Recommendation Report for Planning Permission for Works or Extension to a Dwelling

REF NO: R/188/18/HH

LOCATION: 81 Sea Avenue
Rustington
BN16 2DR

PROPOSAL: One & two storey extension to (South) side & rear (East)

PROPOSED ELEVATIONS 1:100

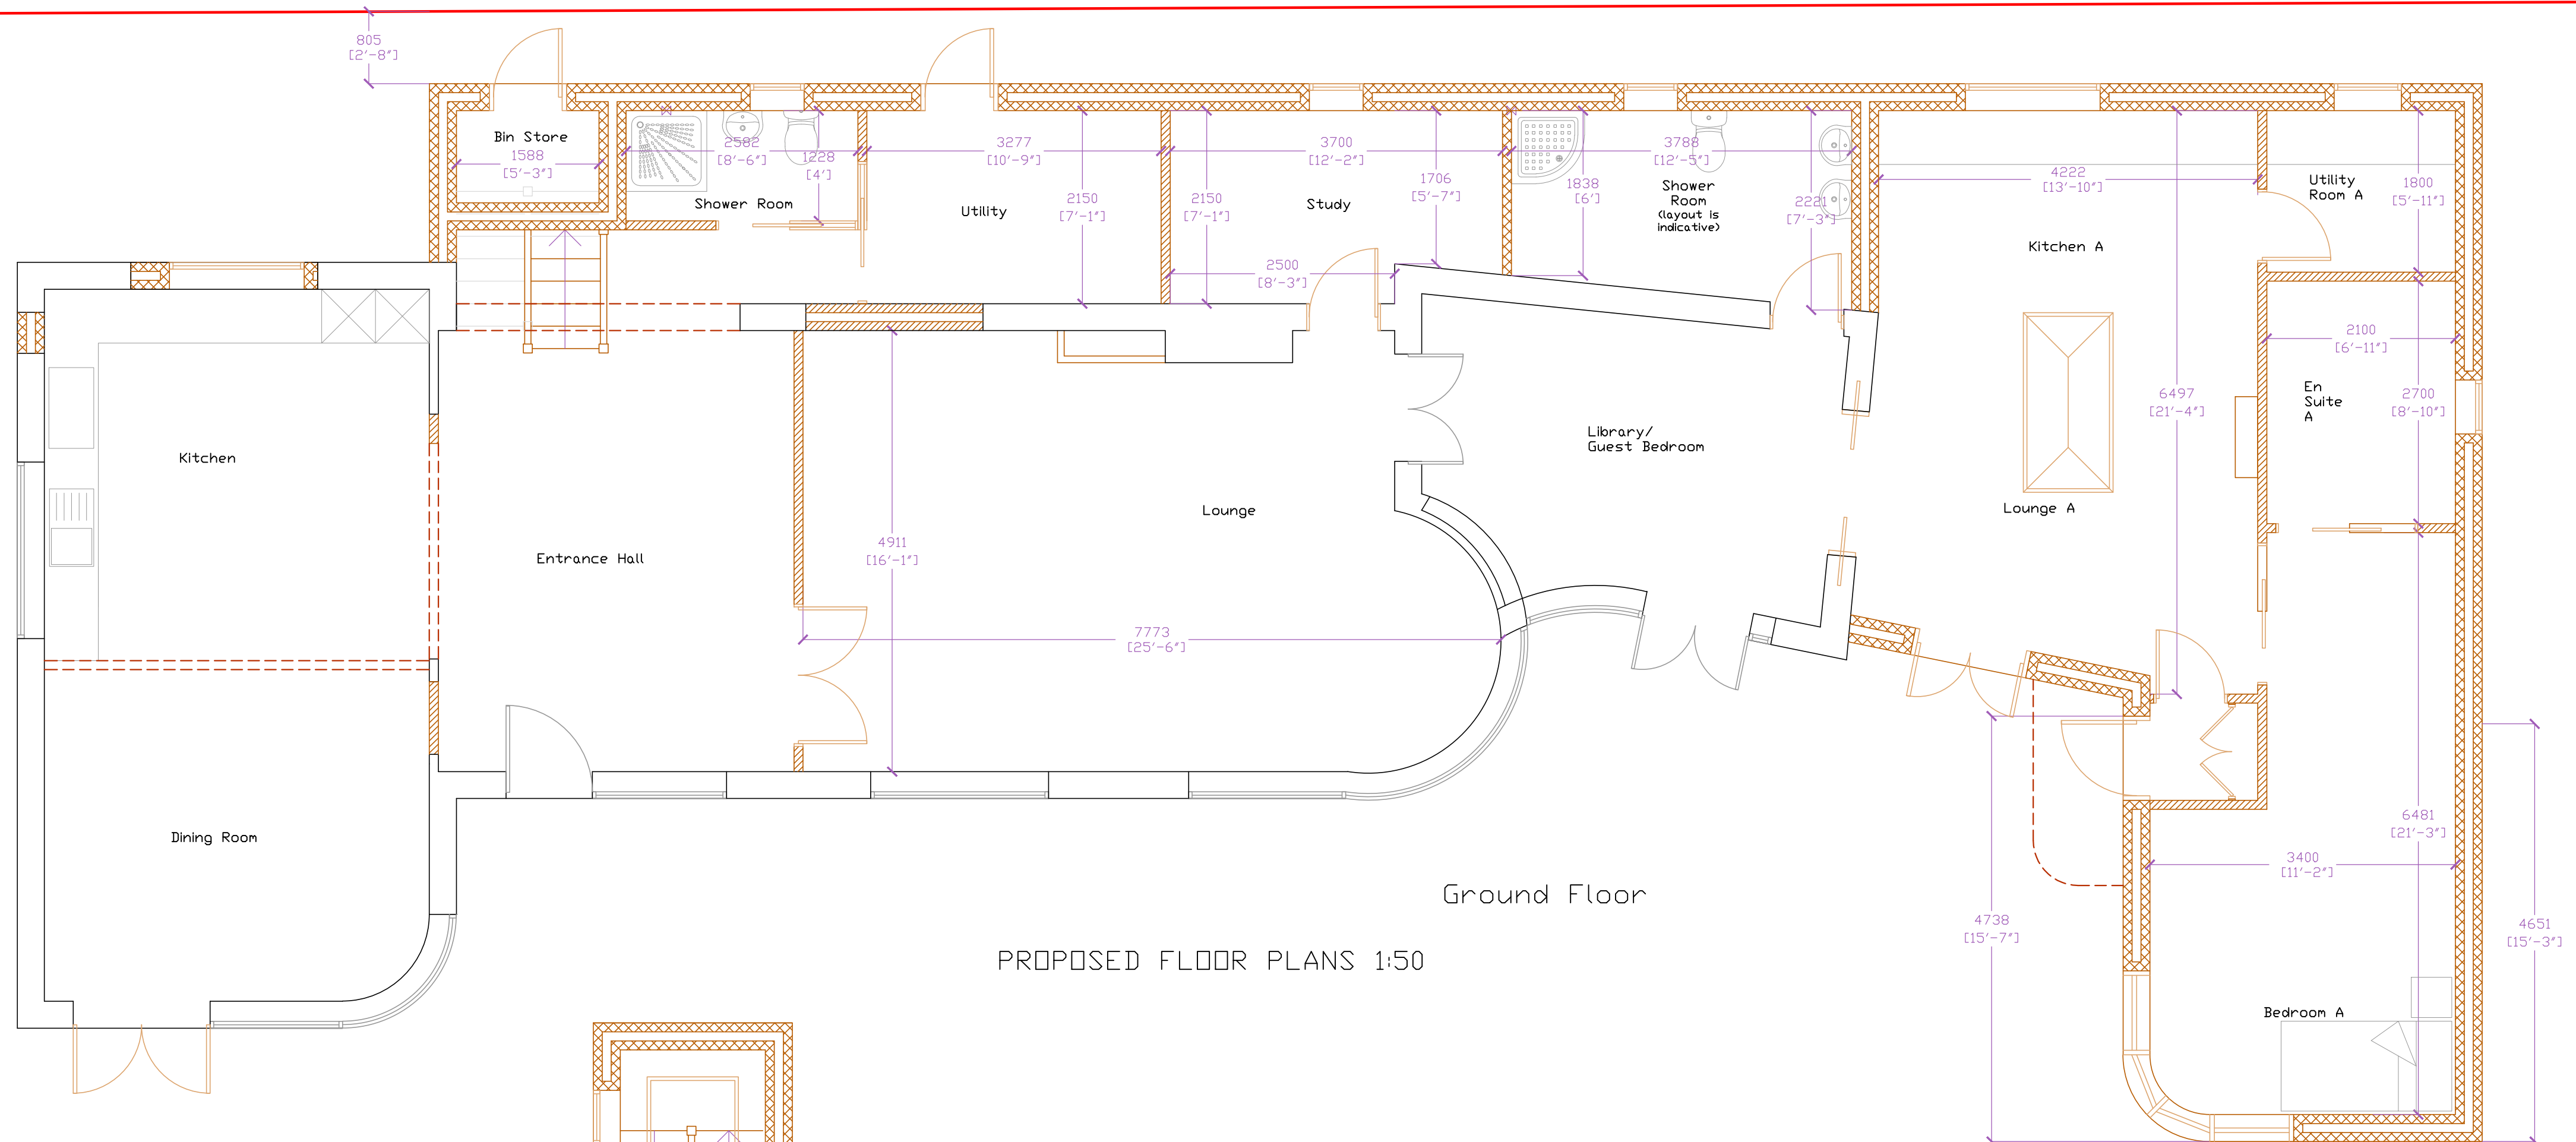
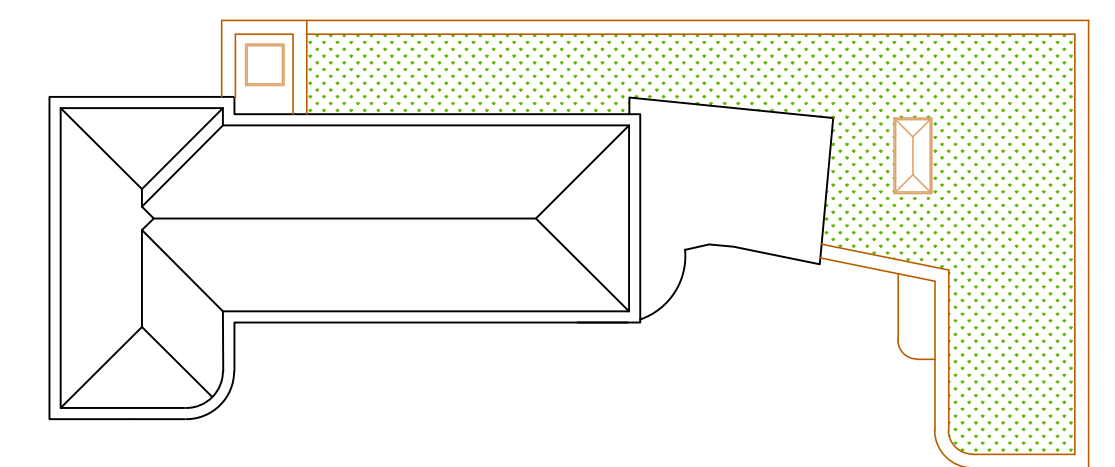
The proposed alteration links the previously approved side and rear extensions. This would be by way of a 2.4m long wall that connects the two extensions. It matches the roof and eaves height of these extensions, it is also made of matching materials. The proposed development is screened by significant foliage to the South, and by 2m high fencing to the East. Equally positioned to the rear of the existing dwelling and between structures that were approved under R/114/15/HH the linking section is screened

from the street scene so does not negatively impact in this regard. It is matching in height with what has already been approved and so is sympathetic to the design of the host dwelling.

By reason of its acceptable height, boundary screening and lack of openings the proposed change in the development is not considered to result in any significant change in neighbouring residential amenity. Therefore, it is in accordance with D DM1 and D DM4 of the Arun Local Plan.

The reason for this being that that condition is not considered to have been necessary. The site is well screened and loss of privacy/overlooking does not arise from any of the works. New openings are at ground floor level, except for the north facing stair window. Formation of further windows on the stair wall can be controlled by condition.

- 5 The window in the side (north) elevation of the two storey staircase element of the extension hereby permitted shall at all times be glazed with obscured glass and be non-opening.
